KITTITAS COUNTY FIRE MARSHAL'S OFFICE

Re: Crowley (BL-17-00001)

After conducting a review of the above named project, I have the following comments:

**CROWLEY PROPERTY**

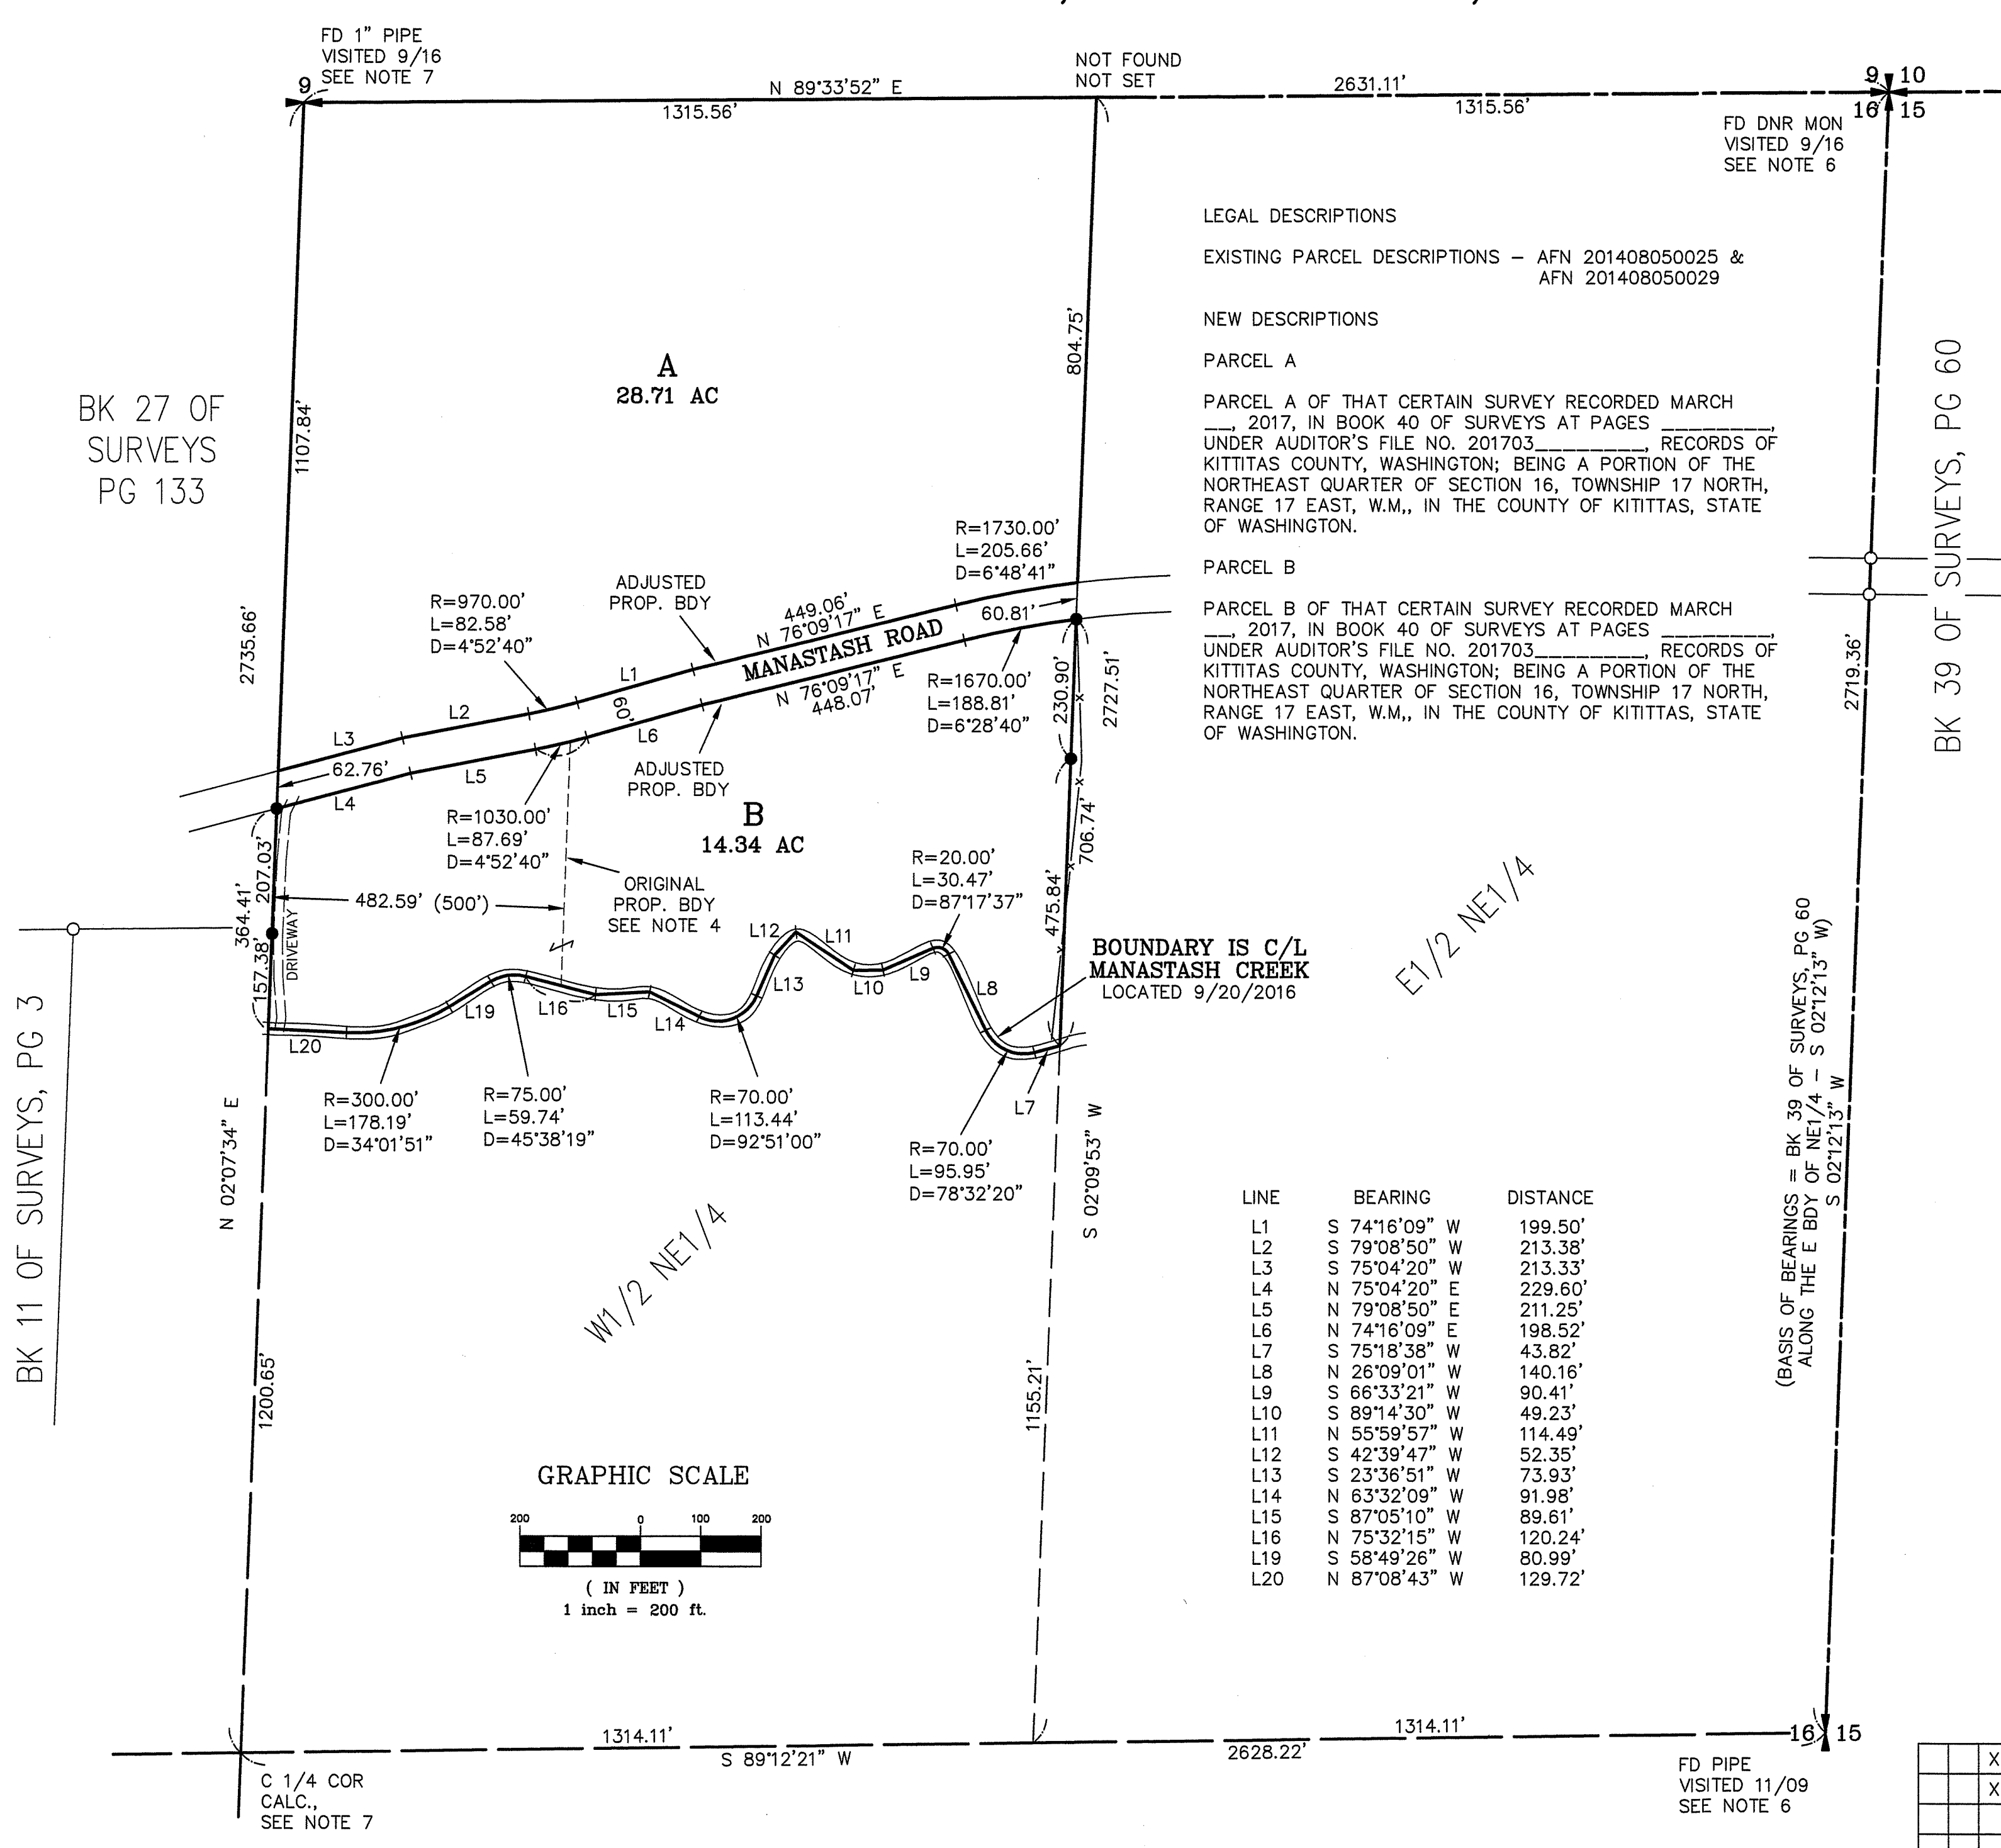
- Ensure that boundary line adjustments do not infringe upon existing structures, to include propane tanks, etc.
- Ensure adequate access for fire apparatus. Any driveways or access points created based off the new lot configurations shall comply with Kittitas County Code 20.02.030.
- All future development must comply with the International Fire Code.
